City of Albuquerque

GRADING & DRAINAGE PLAN FOR BLEA BRYN MAWR SUBD (H16-D110)> RE: RECEIVED AUGUST 17, 1995 FOR BUILDING PERMIT

Based on the information included in the submittal referenced above, City Hydrology accepts the Grading & Drainage Plan for Final Plat & Work Order. Typically, City Hydrology does not review subdivisions for Building Permit.

PLAT OF LOTS 6A THRU 10A, BLOCK 7, 22A & 23A, BLOCK 6 MIRACERROS ADDITION

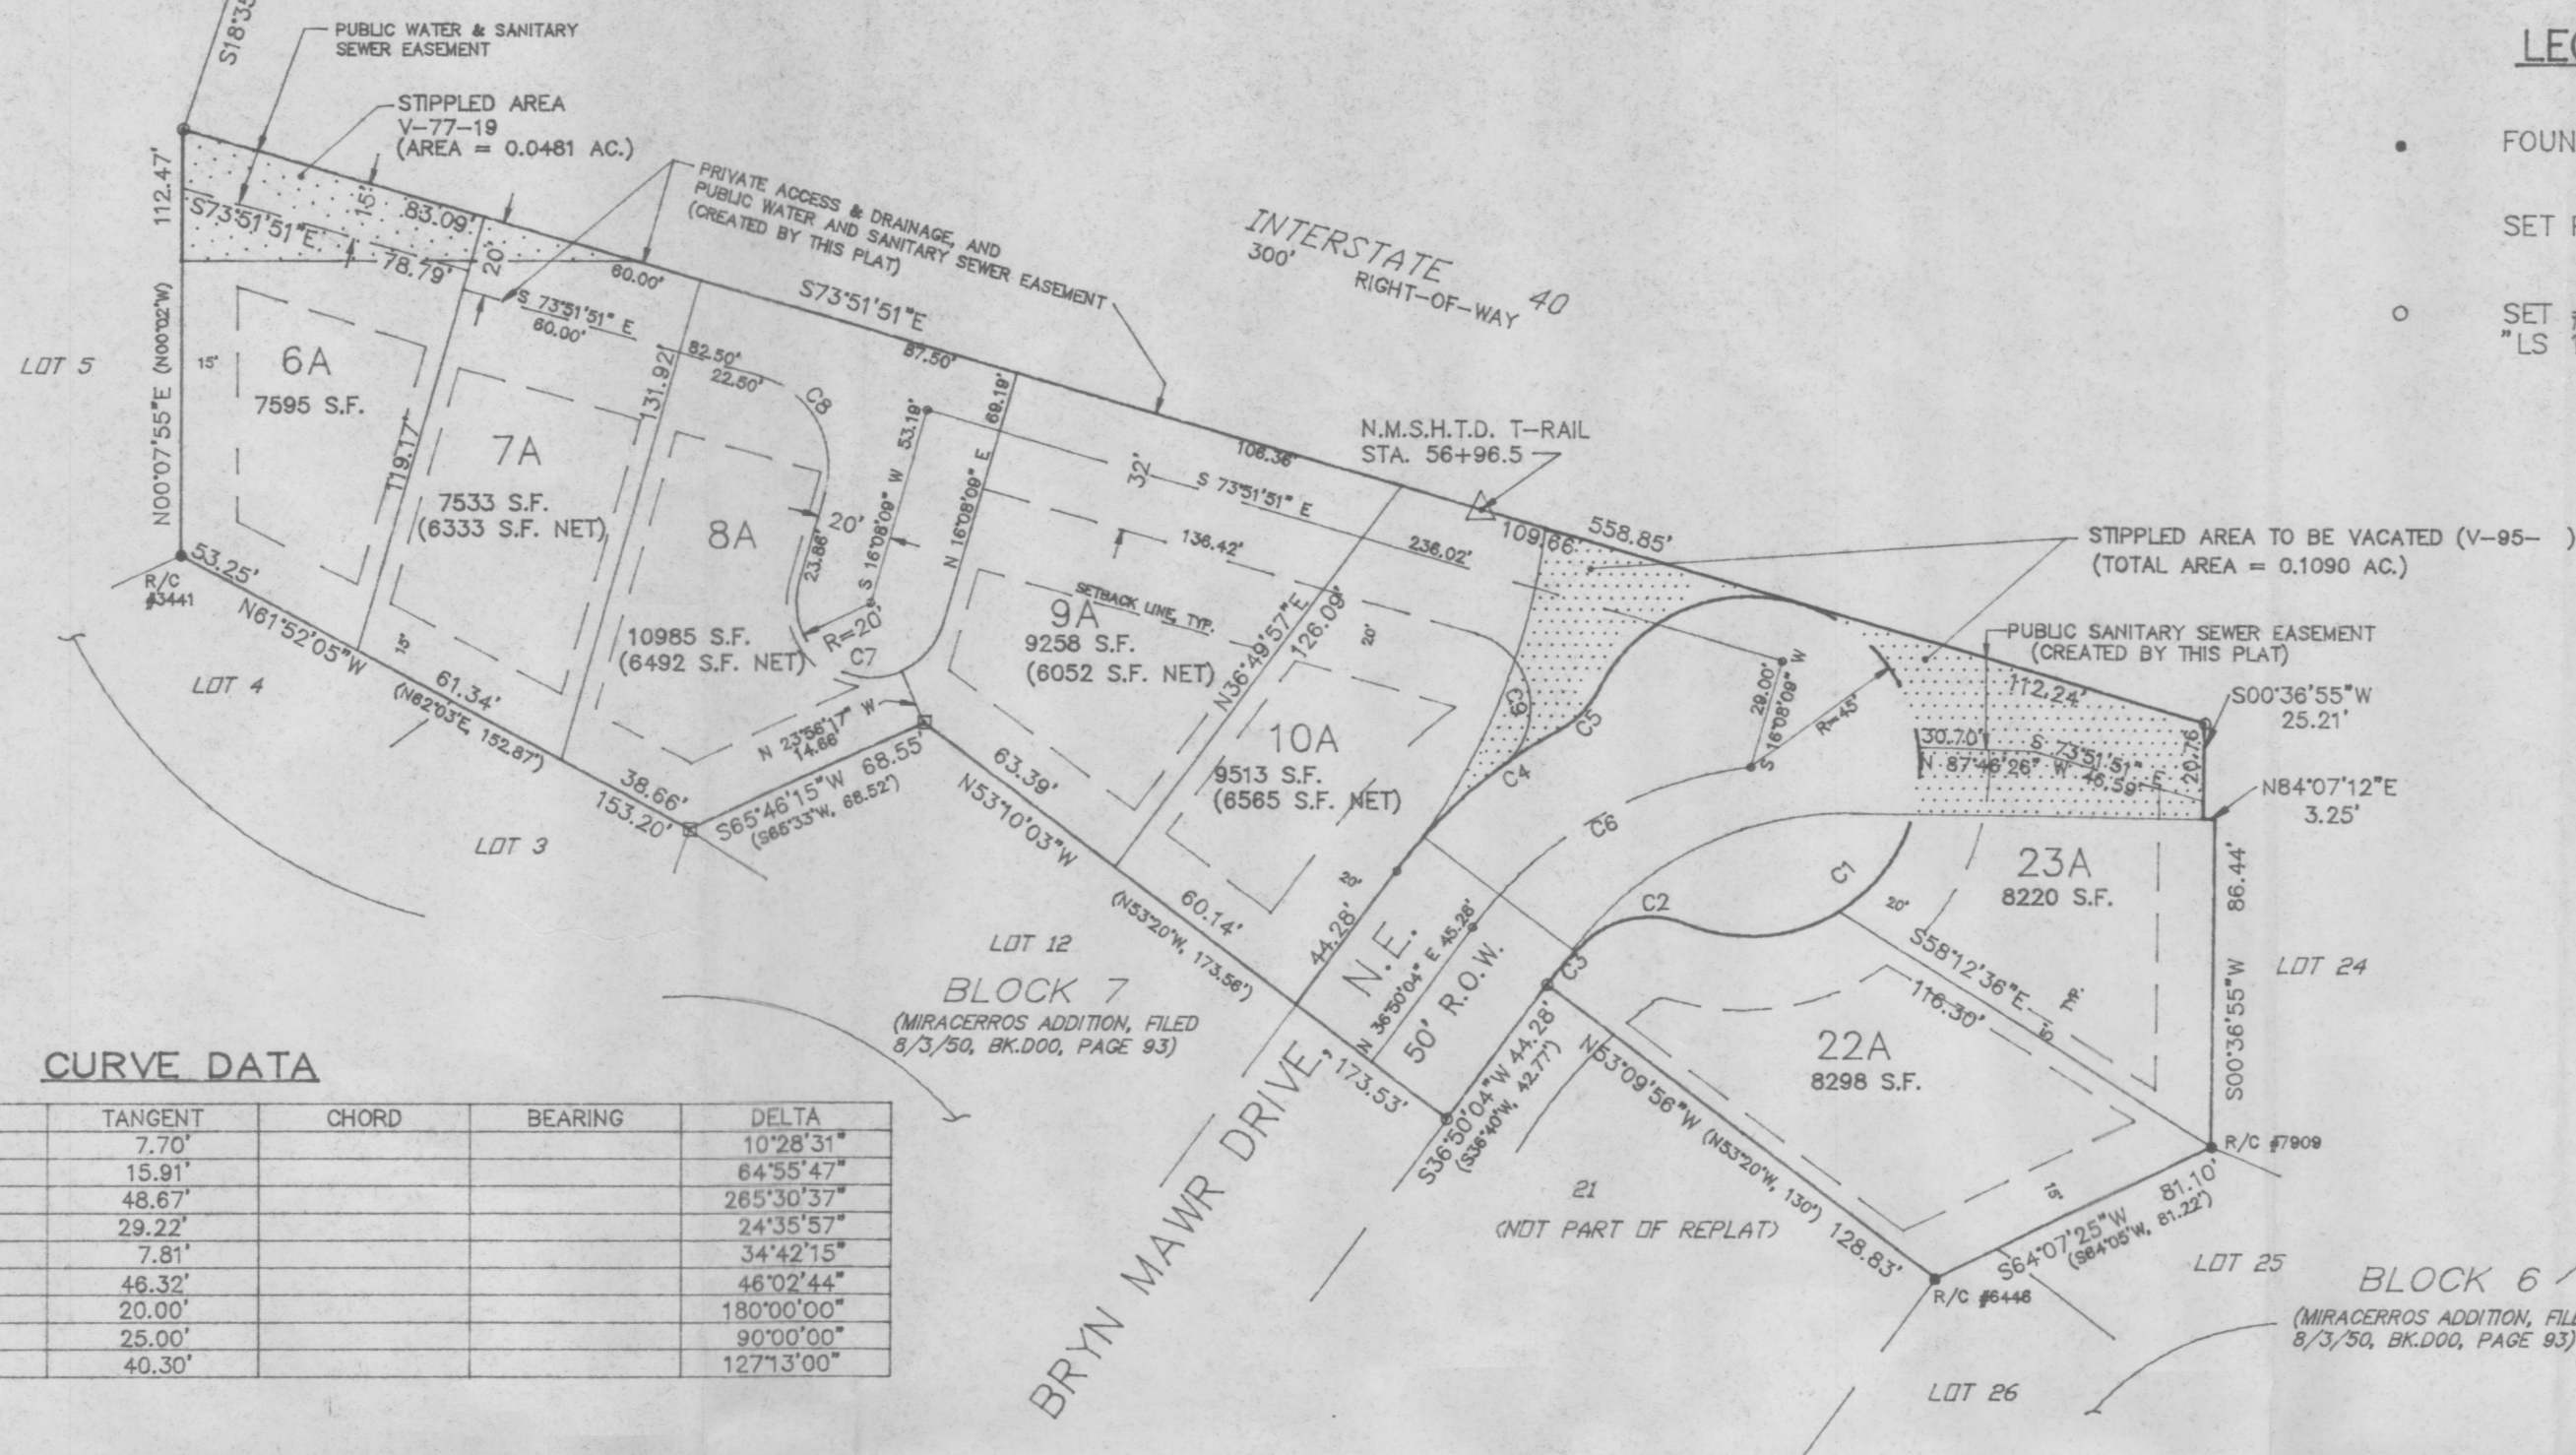
It appears a greater tangent length (20 ft. instead of 6.27 or a point) is needed for possible connection of Bryn Mawr with I-40 trail.

Maintenance and beneficiaries of easements need to be clearly noted; retained easements from V-77-19 need to be noted.

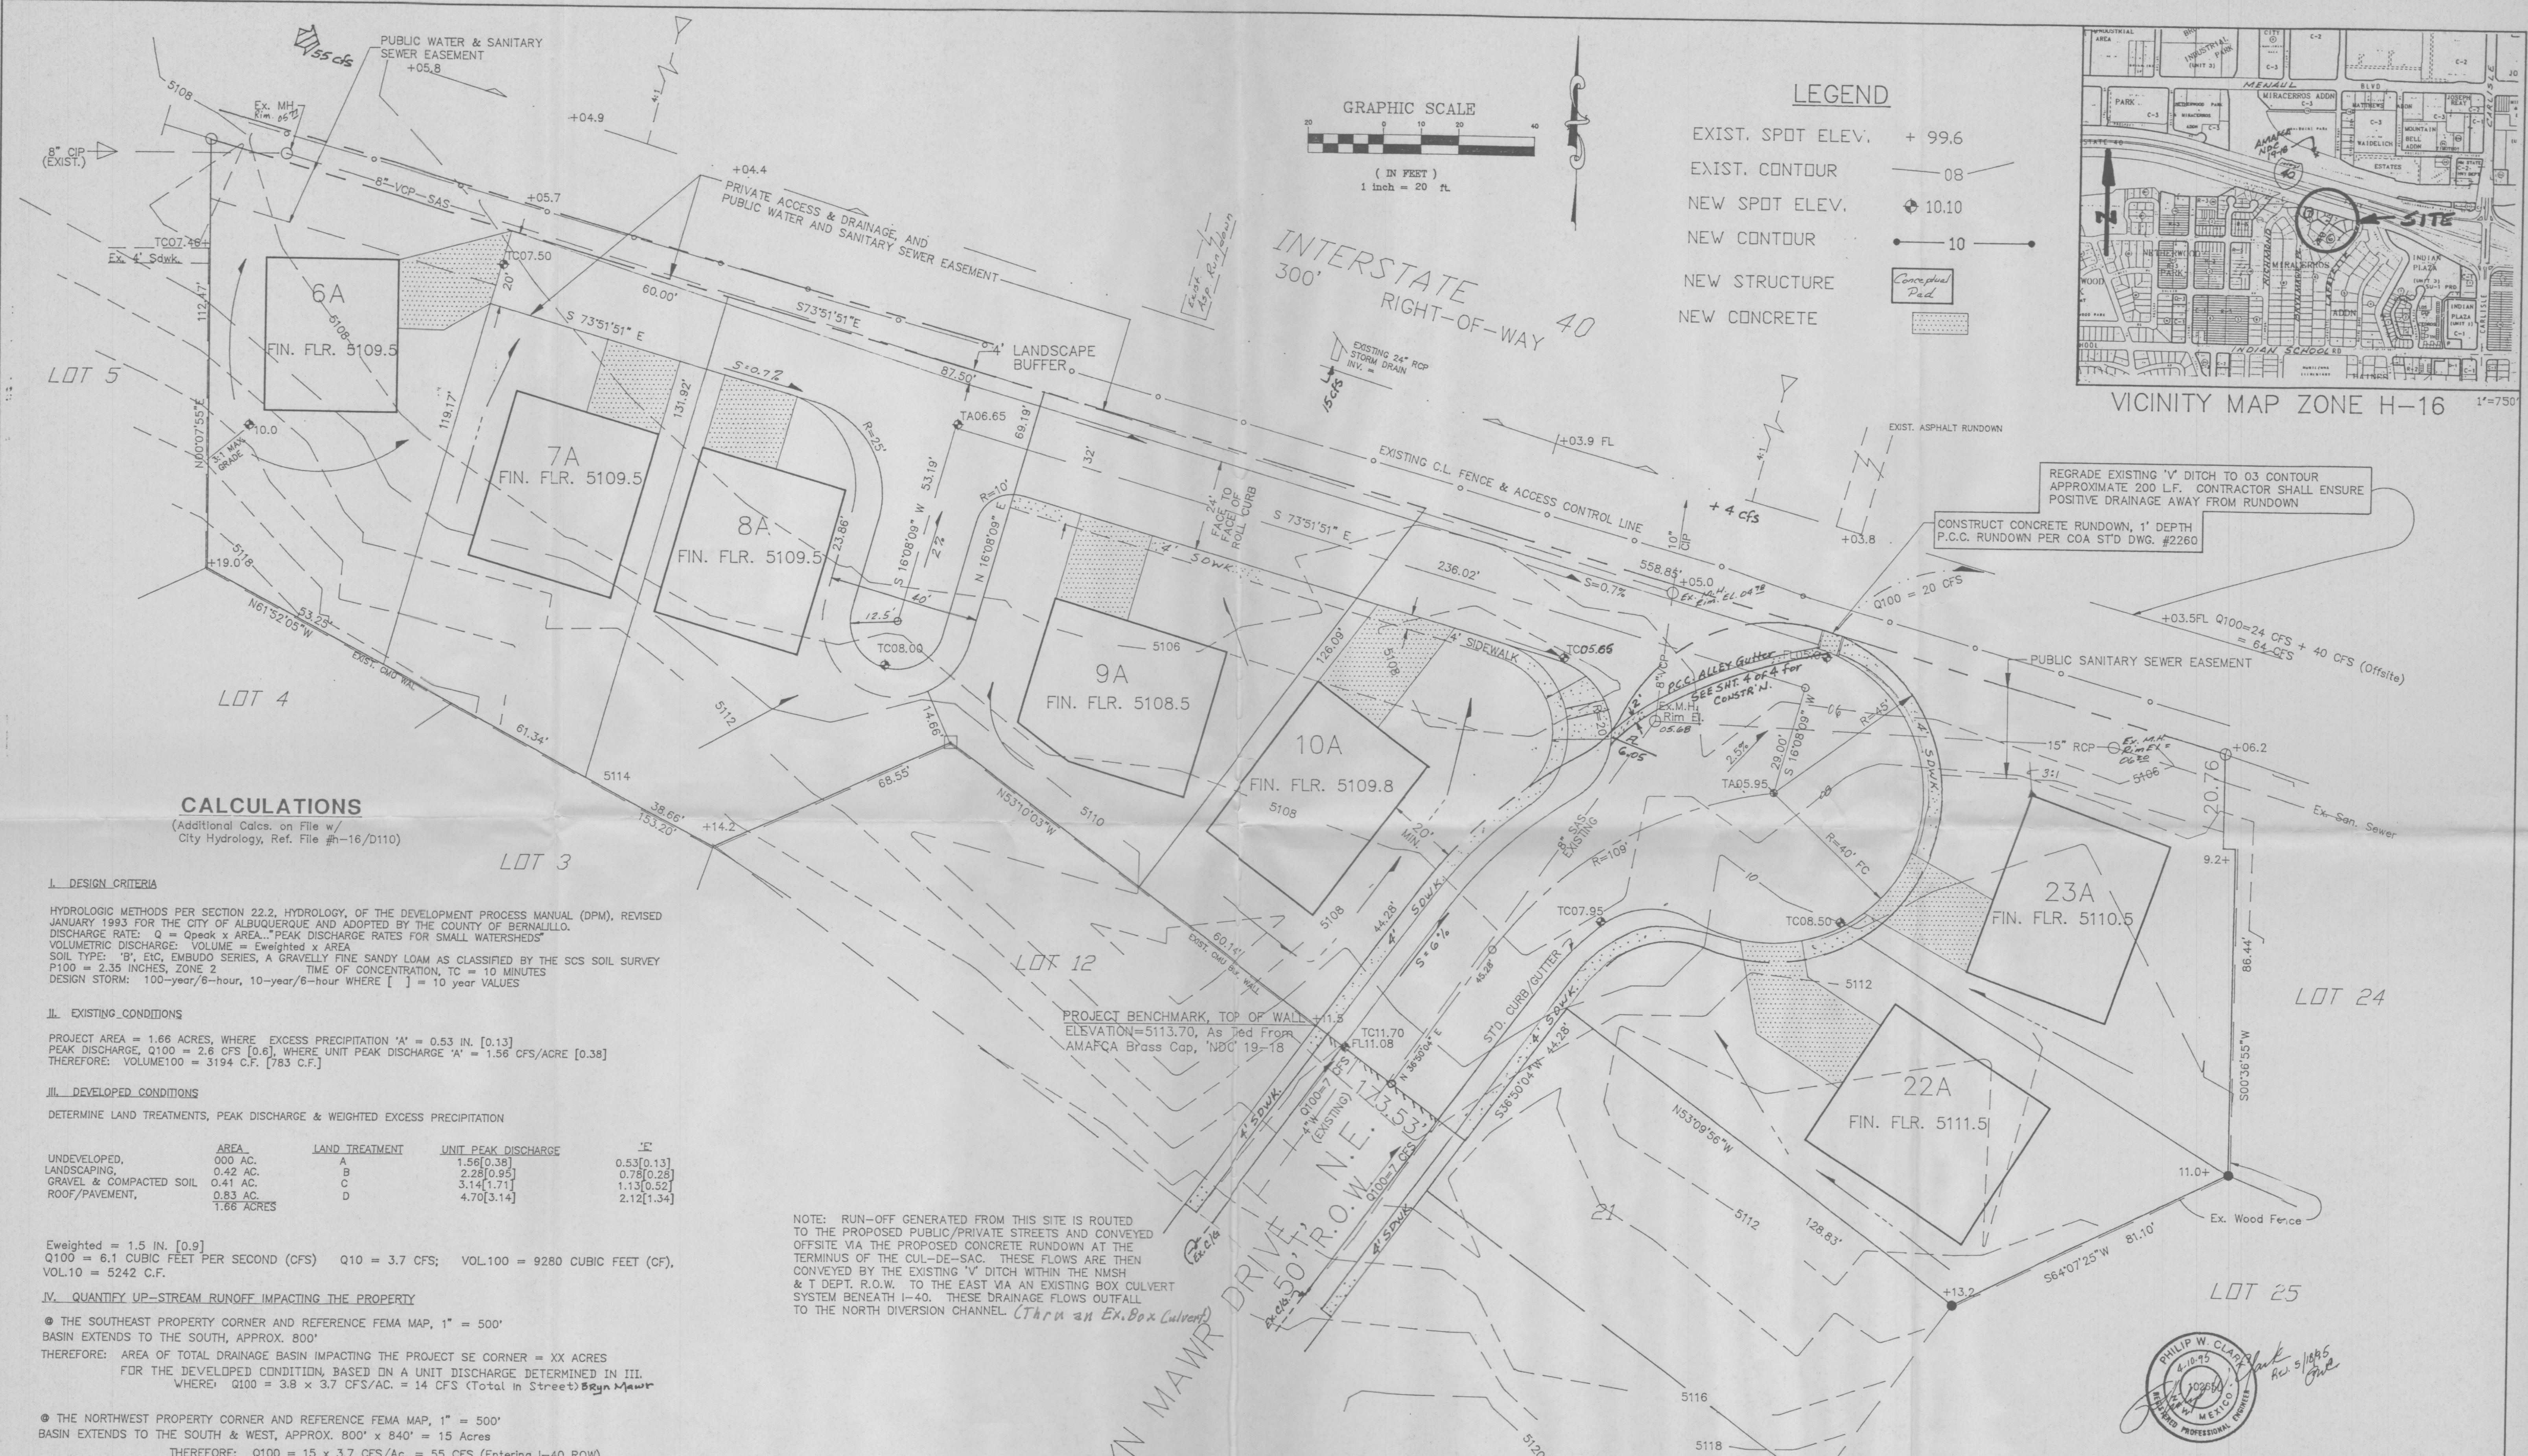
What is the DRB number? Include a copy of the Infrastructure List in the next submittal. The DRB may require that the new pavement on Bryn Mawr connect to the existing pavement. A permit is required from NMSHTD to work in their right of way.

Provide proposed (new) elevations at every other corner of each lot, minimum. Odd shaped lots may require more elevations. It is not clear whether the spot elevations shown are existing or new. Include top of curb & flow line elevations.

Verify downstream capacity. Trace the route of discharge to the North Diversion Channel. The NMSHTD must approve the discharge to their right of way.
